From: GARRY SLEET
Sent: 15 April 2014 14:17
To: Janice Chapman
Subject: Re: EG/5/14 - Ground floor extension and loft rooms. 49 Elm Grove, Eastergate

Subject: EG/5/14 - Ground floor extension and loft rooms. 49 Elm Grove, Eastergate

Subject: EG/5/14 - Ground floor extension and loft rooms at 49 Elm Grove, Eastergate

Revision	Date	Description
B	24-03-2014	Gate changed
A	25-02-2014	Notes changed
Scale:	Date:	Drawn By:
1:100	18/12/2013	BE
Drawing Number:	Revision:	
1112-012	B

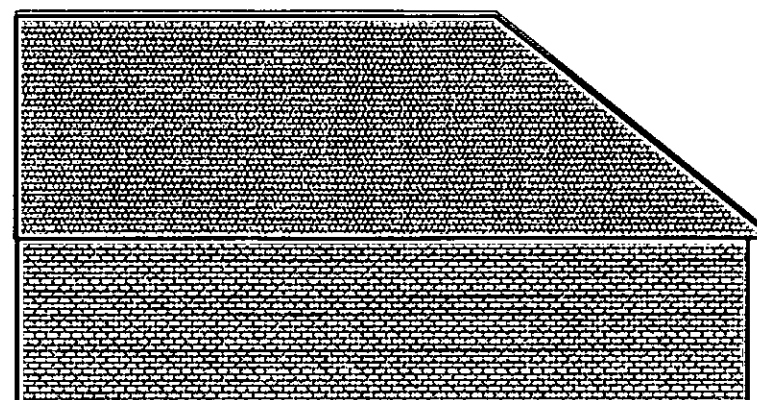
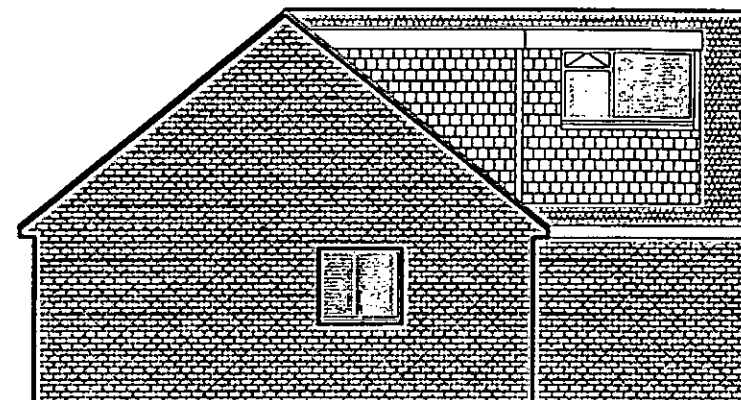
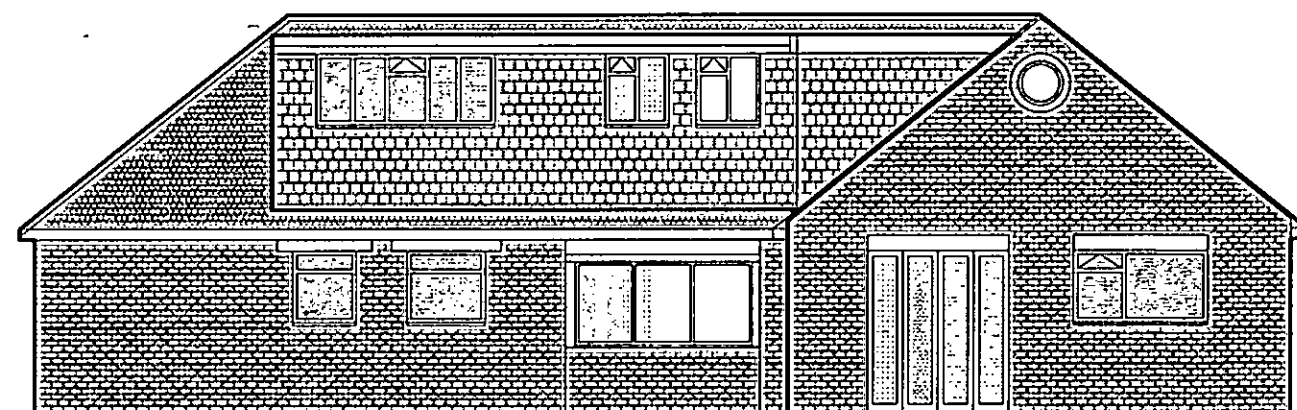
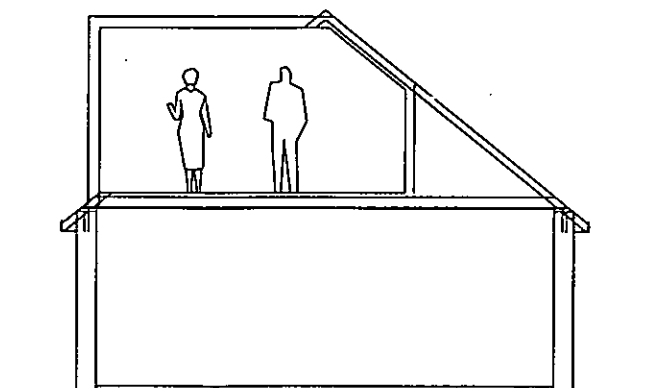
However as you have suggested I have modified the gable and attach the revised drawing for your information.

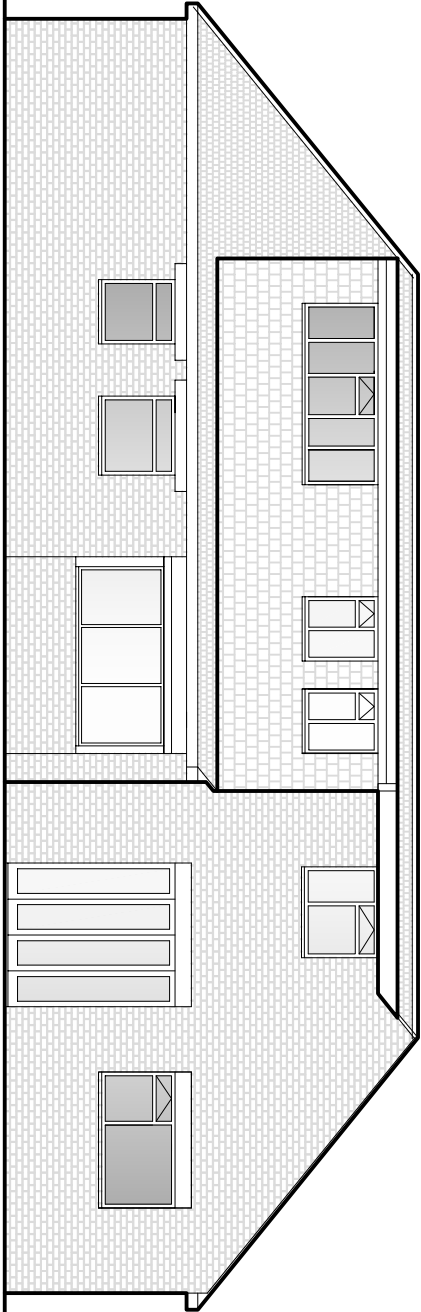
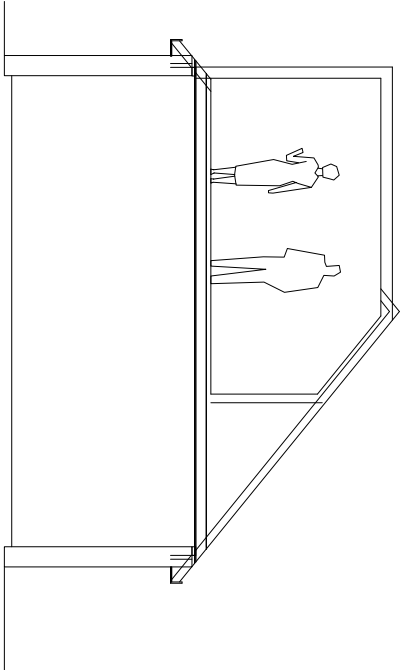
I visited the site this Tuesday 25th February and on inspection of the submitted plans I think that the north side elevation should read south side and north side should read south side. The bedroom window on the rear when scaled at 1:50 is 1.8m in width but on the rear elevation at 1:100 it scales at 1.8m.

The extended rear elevation adjacent to my property advances (to a single storey structure) a two storey structure with a 'chopped' roof, and I attach a rough sketch in perspective of how this impacts on 48. The impact is not insignificant or 'little changed'. There are two windows to the upper storey bedroom. The one facing the rear gardens is the one of concern. It is a window overlooking both gardens- 48 and 49-and therefore presents an " overlooking "issue. This appears not to have been recognised in the design. I would add that this window is dimensioned at approx 1,1m wide on elevation, but at 1.8m on plan.

I have had a look and yes minor errors, all corrected. Attached new revised drawings.
